Doc no. DOC19/593791
File no. SF19/76662

**RE: Response to Response to Submissions (RTS) of Sydney Opera House (SOH)
Building Renewal Program – Concert Hall Upgrade and new Creative Learning Centre
(SSD 8663)**

ATTACHMENT A: SYDNEY OPERA HOUSE BUILDING RENEWAL PROGRAM
CONCERT HALL & CREATIVE LEARNING CENTRE HERITAGE RESPONSE TO
SUBMISSIONS RESPONSE

SECTION 60 APPLICATION
SK- ARM-9247 15TH OCTOBER 2019

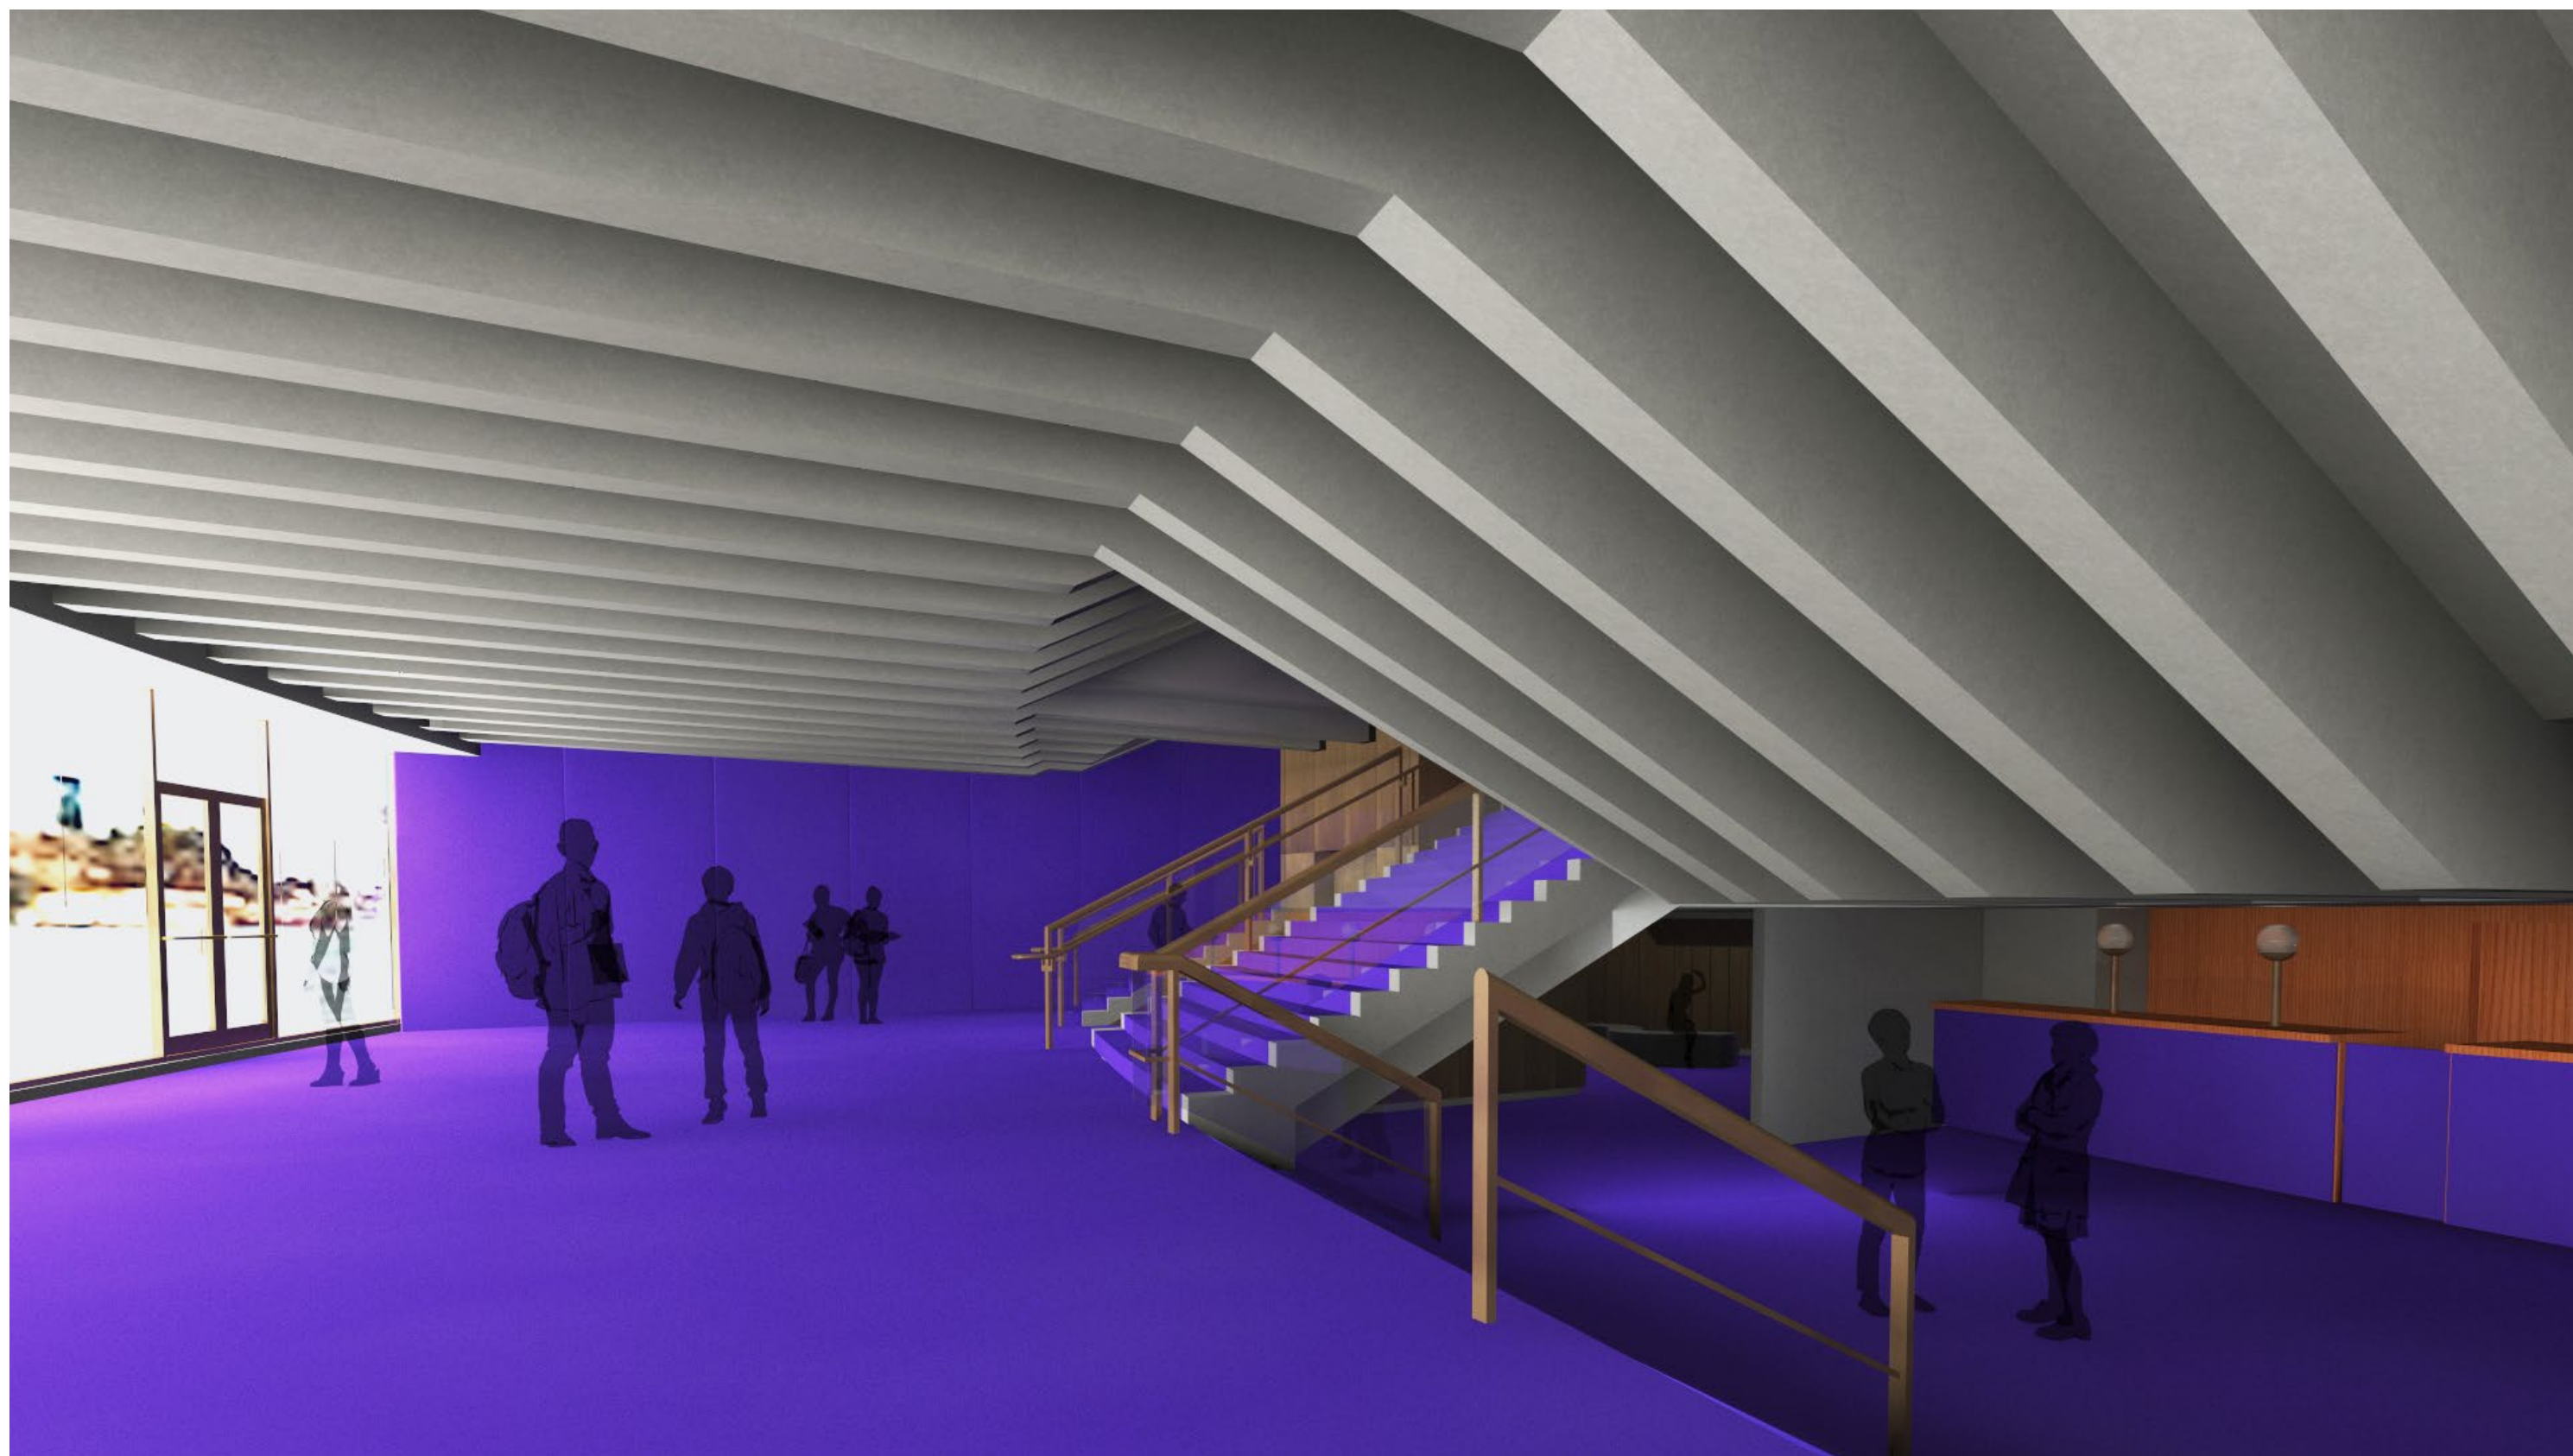
- 2.23 It is still considered that the proposed detail to extend two beams to the new lift adversely impacts the aesthetics of the distinctive bend line of the cranked beams. The design of this detail requires further refinement to better integrate the beams within the existing significant design aesthetic and minimise visual impacts.

- 2.24 The proposed detail of the extension of two cranked beams connecting to the new lift should be reviewed and revised to minimise visual impacts and to ensure the new works do not disrupt the aesthetic qualities of the distinctive line of crank points in the beams.
